Item No. **Report of the Head of Development Management and Building Control**

Address: 5-7 HERCIES ROAD HILLINGDON

Development: Change of use from Use Class E to mixed use of Class E and Sui Generis (Massage and Beauty Shop) and merging shop nos. 5-7 & 9-11 into one single unit.

LBH Ref Nos: **78371/APP/2023/3322**

@ISO A3 (297 x 420)		
DRAWN: SC	DRAWING NUMBER	REV.
SCALE: AS SHOWN	2023-5-7HR-PL-1	1.0
DATE: 10/11/2023	SHEET: # 1 / 2

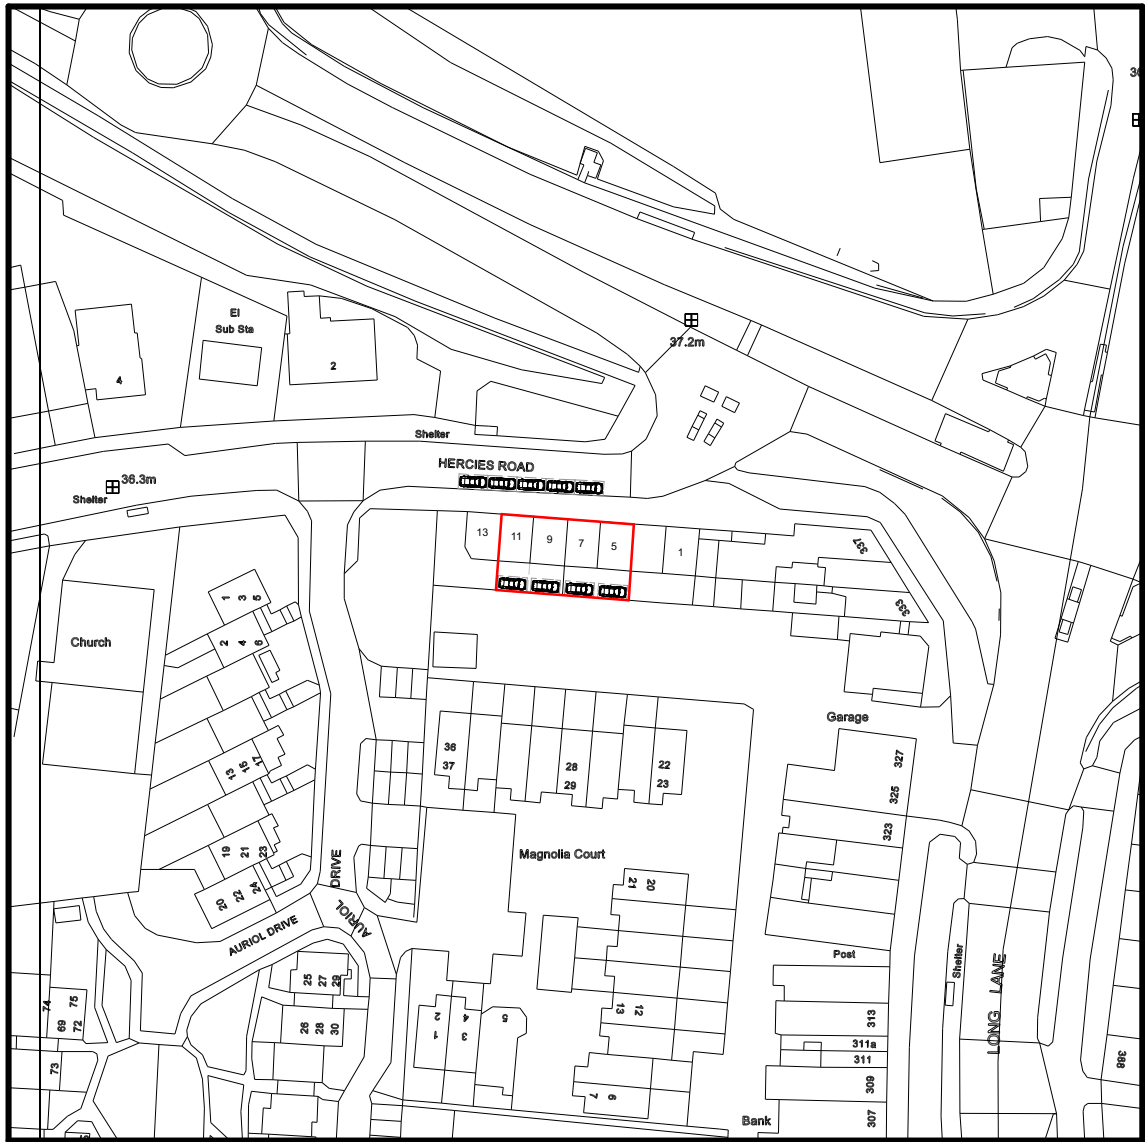
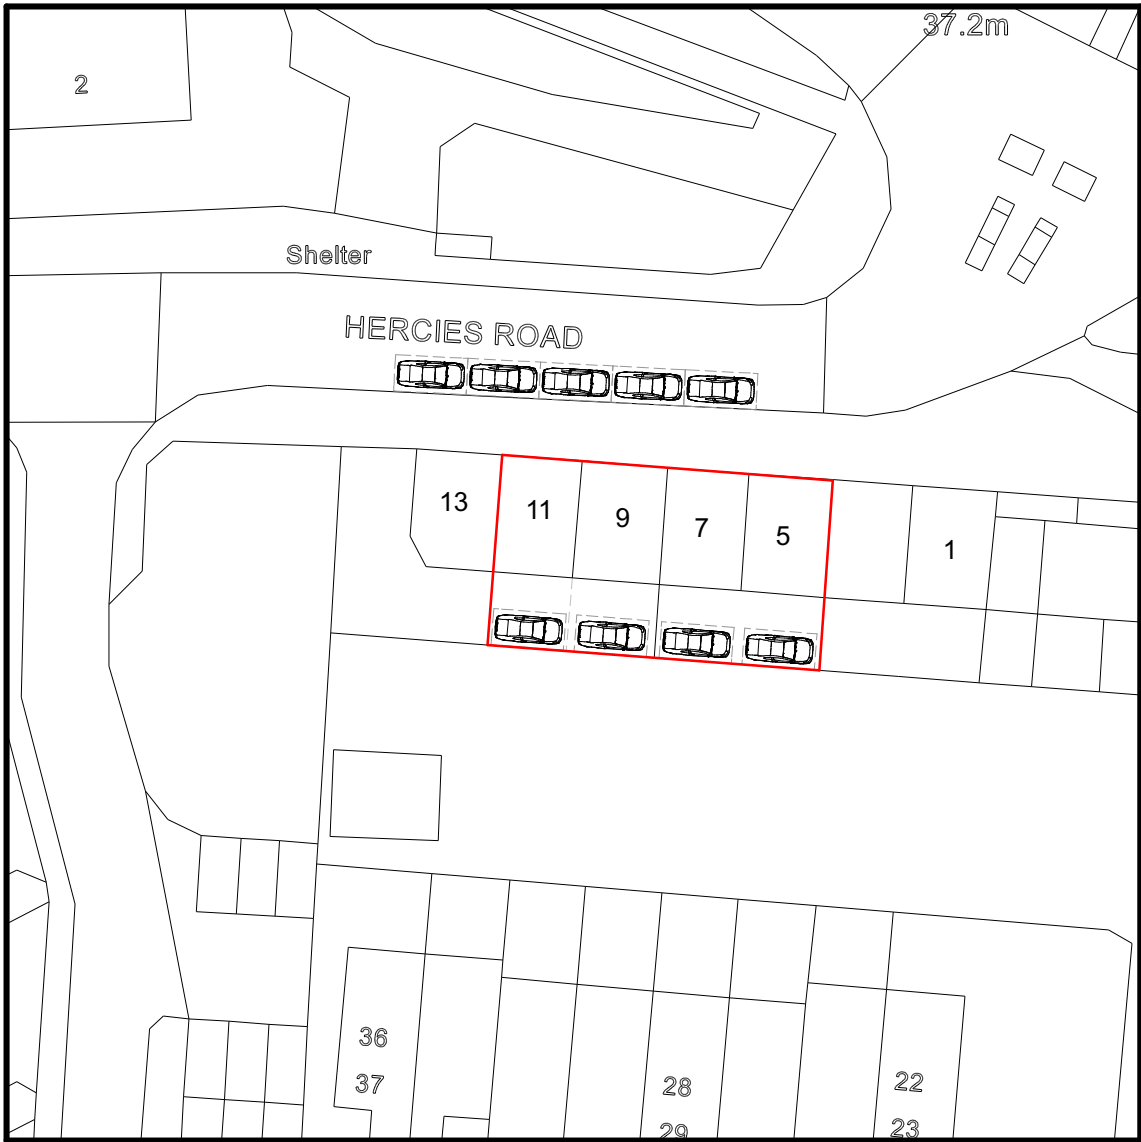
Drawing 2023-5-7HR-PL-1 Rev 1.0A titled Site Plan shows the Location Plan and Site Plan which demonstrates access between the site and the adopted highway, however, a blue line should be provided around 9 and 11 Hercies Road as this would be considered land owned by the applicant adjacent to the application site as detailed within Government guidance which states that;

The application site should be edged clearly with a red line on the location plan. It should include all land necessary to carry out the proposed development (eg land required for access to the site from a public highway, visibility splays, landscaping, car parking and open areas around buildings). A blue line should be drawn around any other land owned by the applicant, close to or adjoining the application site. (Retrieved from Making an application - GOV.UK (www.gov.uk)).

As the proposed change of use relates to both units 5-7 and 9-11 Hercies Road, the red outline around both units is correct.

DRAWN: SC	DRAWING NUMBER	REV.
SCALE: AS SHOWN	2023-5-7HR-PL-2	1.0
DATE: 10/11/2023	SHEET: # 2 / 2

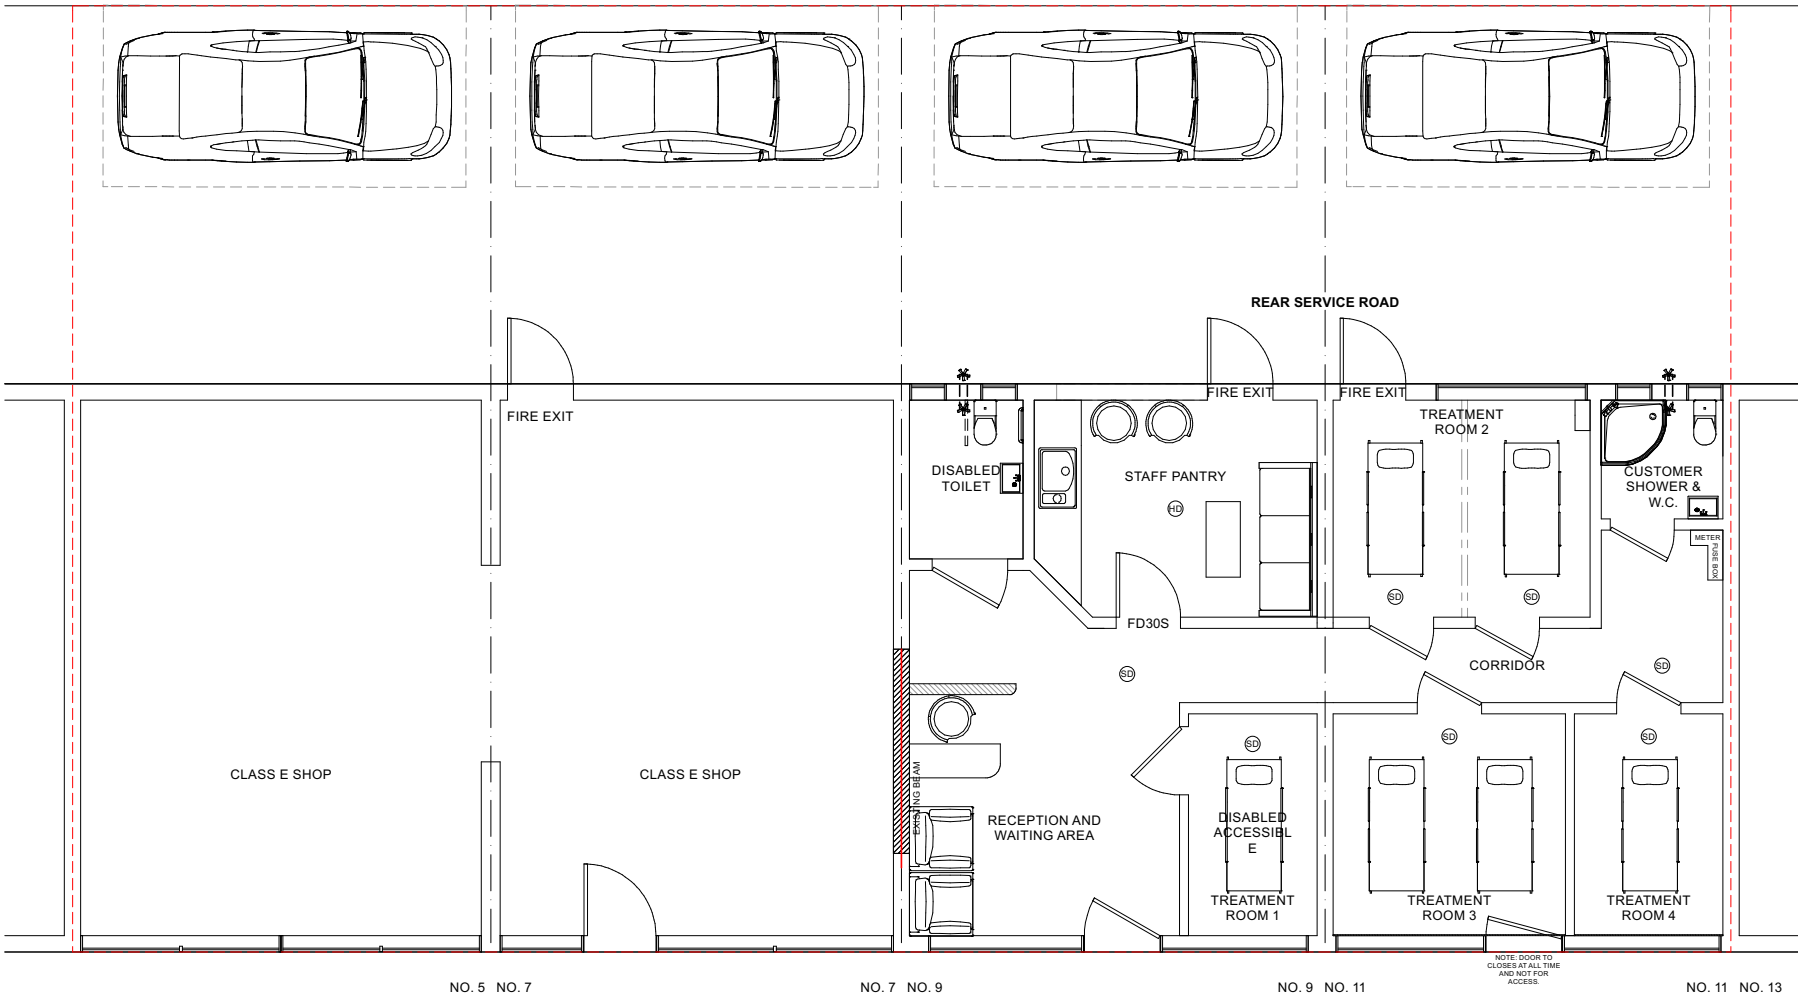
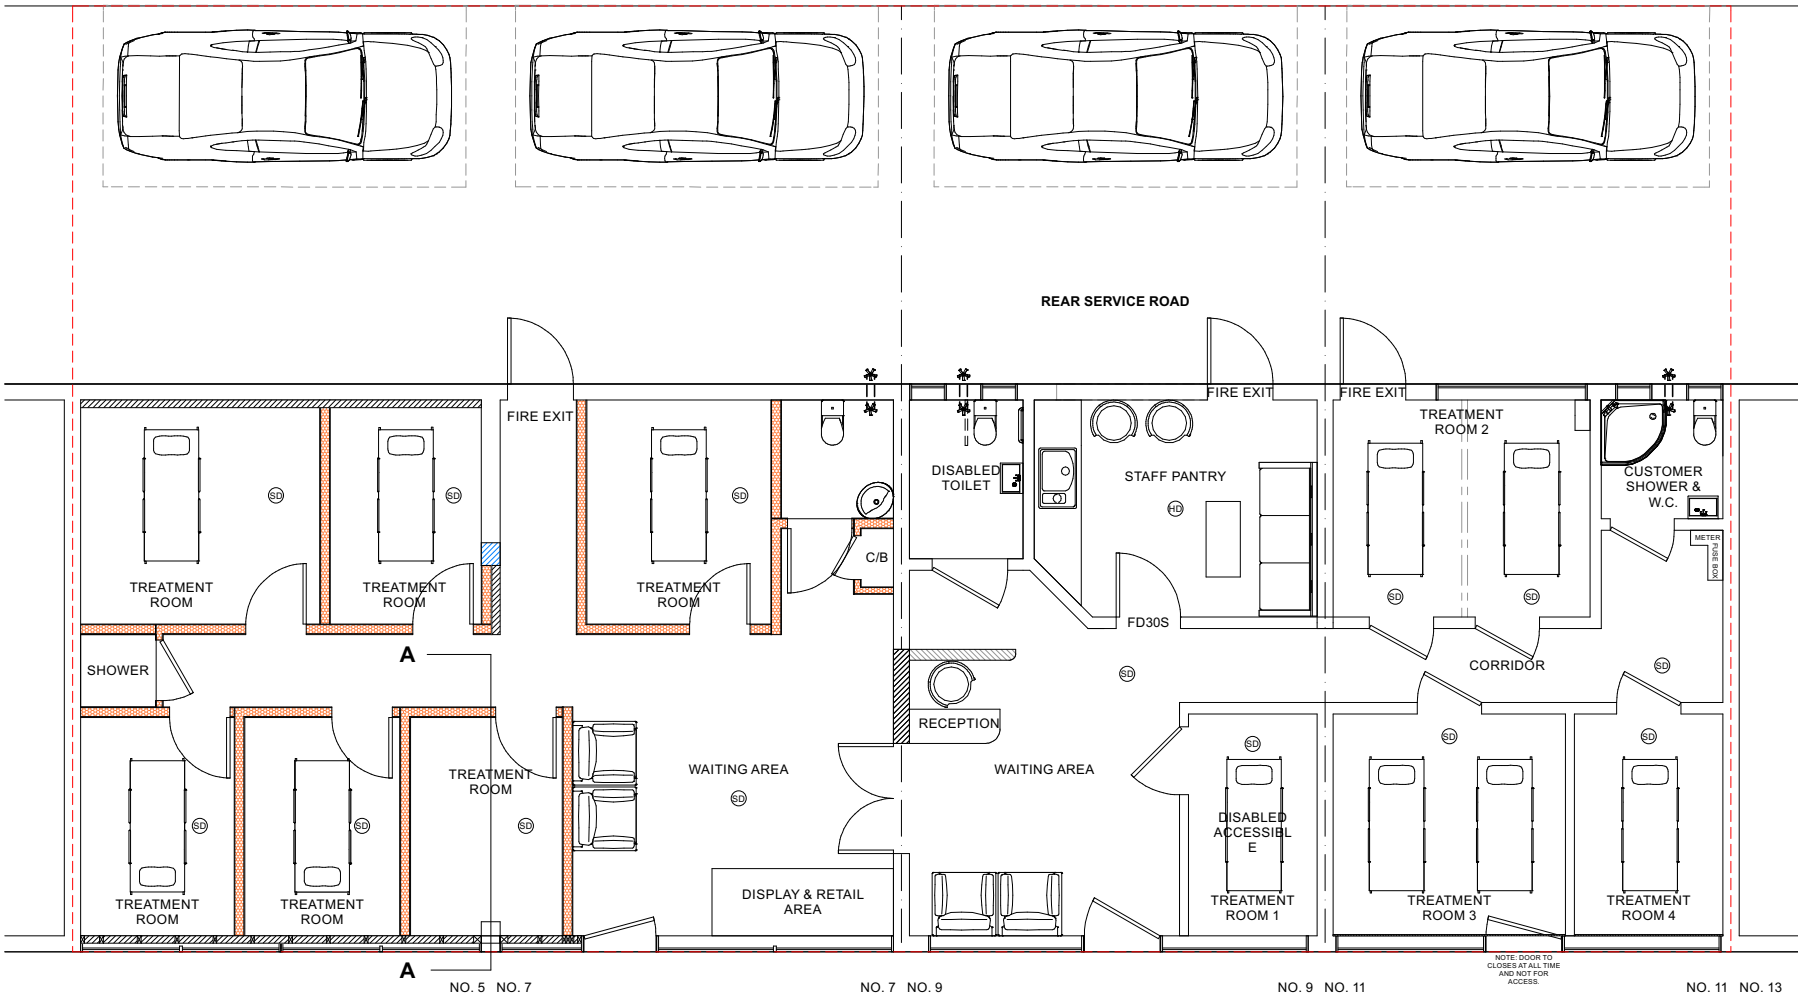
The submission does not include drawings which indicate how the shop frontage would be redesigned to reflect the internal changes. Whilst elements of the works undertaken to the frontage may well be limited, details relating to how the shop front would be amended to notify customers that the operation inside of the commercial unit is the same as the adjacent store should be submitted for assessment. The existing building is occupied or was most recently occupied by a Photograph Studio. According to the submission the frontage would remain the same but the operation with the building would change to a Massage and Beauty Shop creating confusion for potential customers.

It is considered insufficient detail has been provided regarding the frontage of the units. Without these details it cannot be concluded that the merging of the units will not cause harm to the character and appearance of the street scene and surrounding area.

It is noted that there is a previous permission for the merging of shops along Hercies Road under application ref. 74068/APP/2018/3376, however this related to two smaller units and was a retrospective application. This application seeks to extend the already combined unit with another large unit along Hercies Road. Although it is stated that there are no external changes with the proposed development, no elevation plans have been submitted with the application. The majority of this small parade and the parade opposite is characterised by smaller single fronted units apart from the estate agents adjacent to the application site which benefit from a double frontage. However this application would effectively combine two double fronted units which would appear overly large within it's context and fail to respect the prevailing character of the commercial parade. It is inevitable that there will be an impact on the street scene by combing these two large units together and without further details it cannot be concluded that the development would have a limited impact on the character and appearance of the surrounding area and that there are benefits to outweigh the potential harm. The shop frontage does not relate to the occupation shown on the proposed floor plan, and as no work is proposed to the external appearance of the units, it would not read as an attractive and functional Class E/ Sui Generis floor space.
